10 March 2009

Greystanes Industrial Estate Review of Stormwater and Groundwater Site Servicing Strategy

Dexus have provided GHD with a proposed master plan (Drawing No. DX_G_MP08.01 revC) and a number of master plan alternate options (Drawing No. MP-28). These drawings form the basis for our review and assessment.

PROPOSED MASTER PLAN

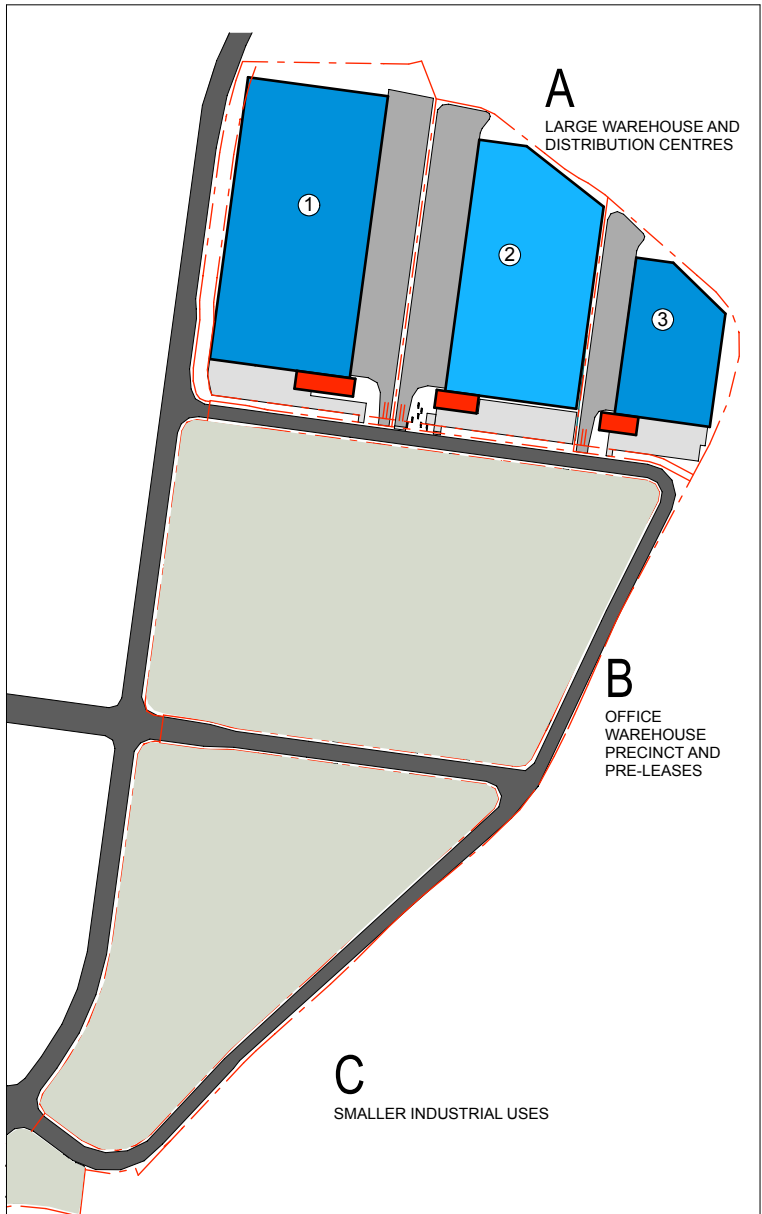
Based on an assessment of Dexus' proposed master plans we believe that similar points of connections could be maintained. However, we note that the drainage system for buildings adjacent to the Spine

Road suits direct connections to the Spine Road. Controls must be in place to ensure that stormwater runoff from these building are directed towards the eastern perimeter drain.

PROPOSED MASTER PLAN

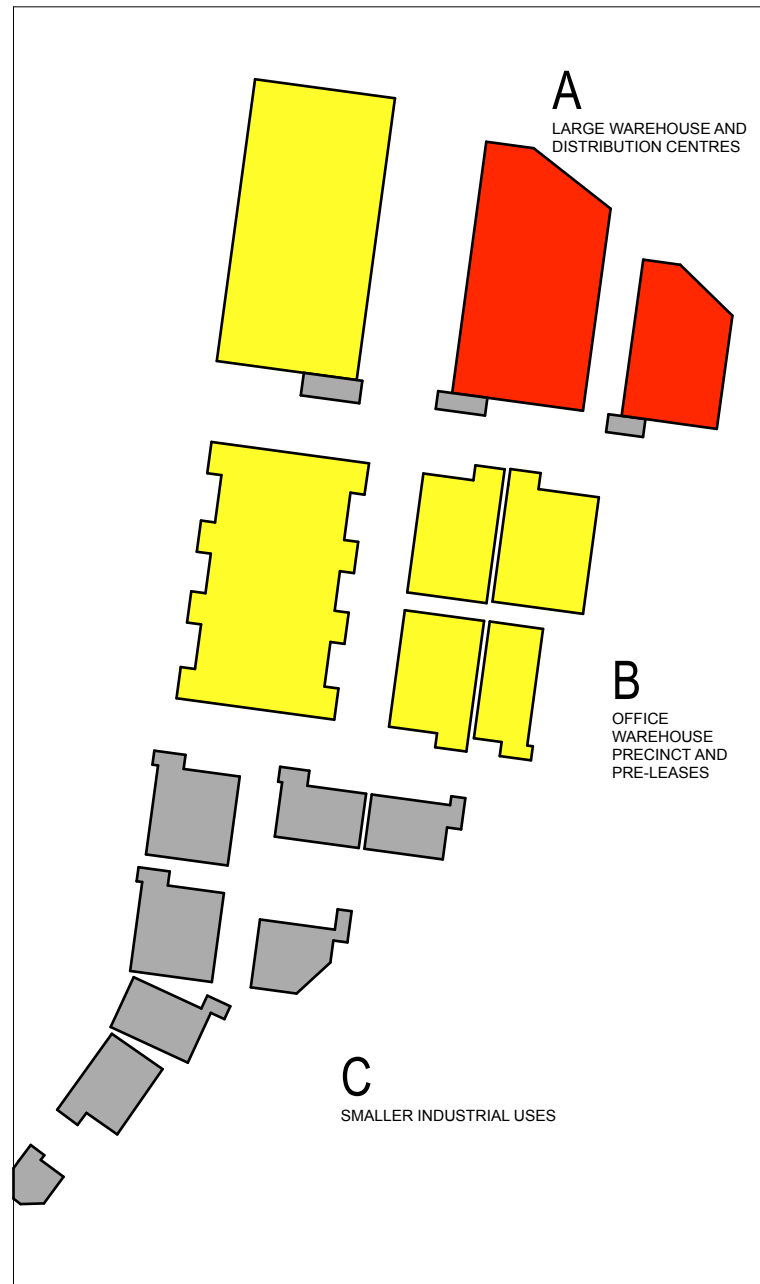
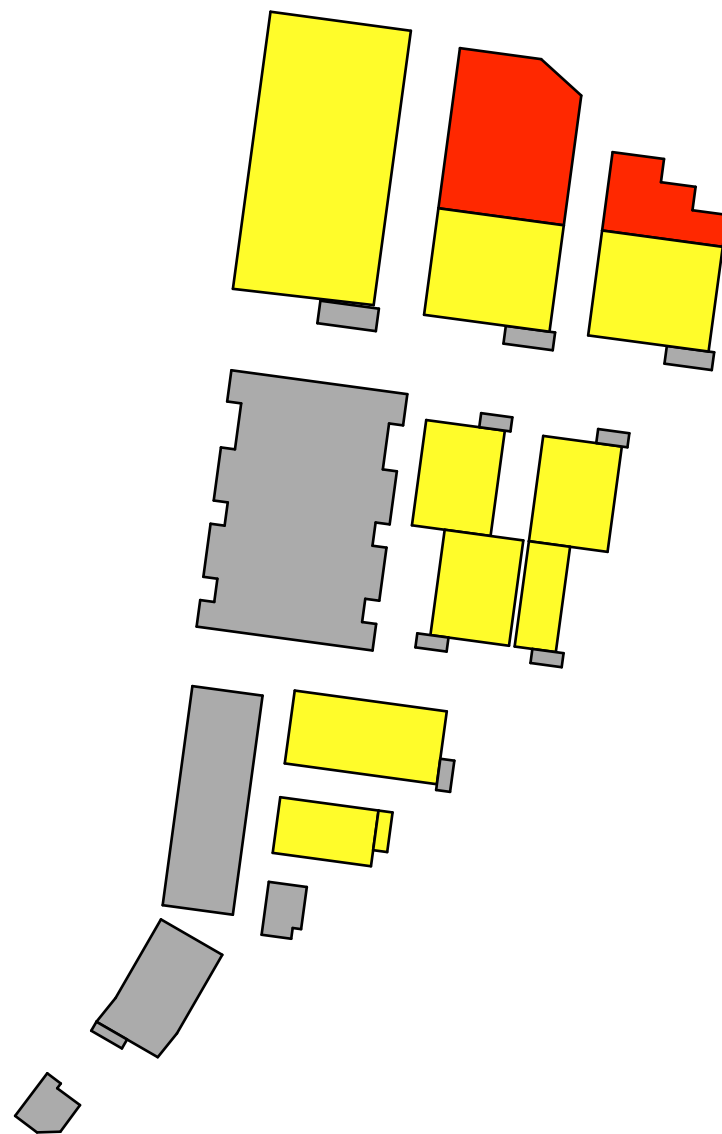
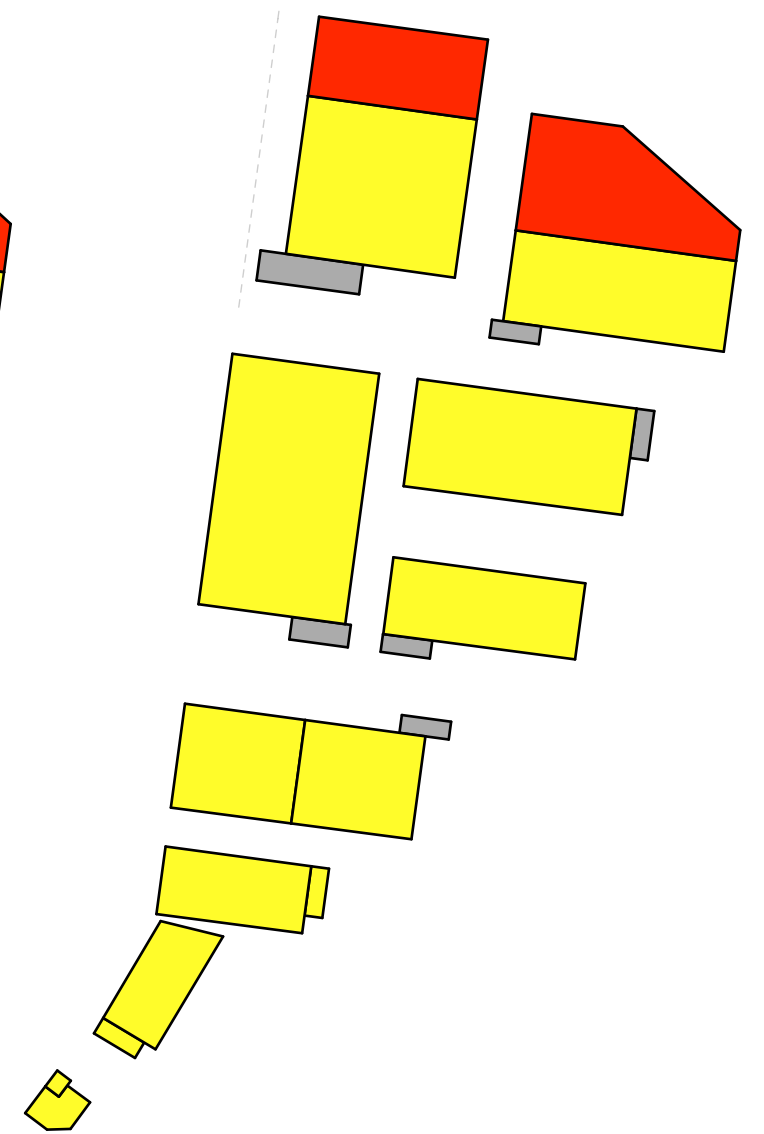
The proposed master plan option drawing (Drawing No. MP-28) indicates that the proposed development would have the following site area breakdowns (including alternate layouts Options 1-3) and their equivalent fraction impervious areas:

The stormwater strategy developed for the site (based on the approved Boral precinct plan) stipulated that approximately 15% of the lots would be landscaped, ie 85% of the lots will be impervious. Based on Table 1 the proposed master plan with a fraction impervious of 85.8%, whilst still generating (negligible) increases in stormwater runoff could be considered to be in accordance with the approved concept plan. The percentage impervious for the alternate options, are either less than 85% or the differences in the impervious areas are negligible.
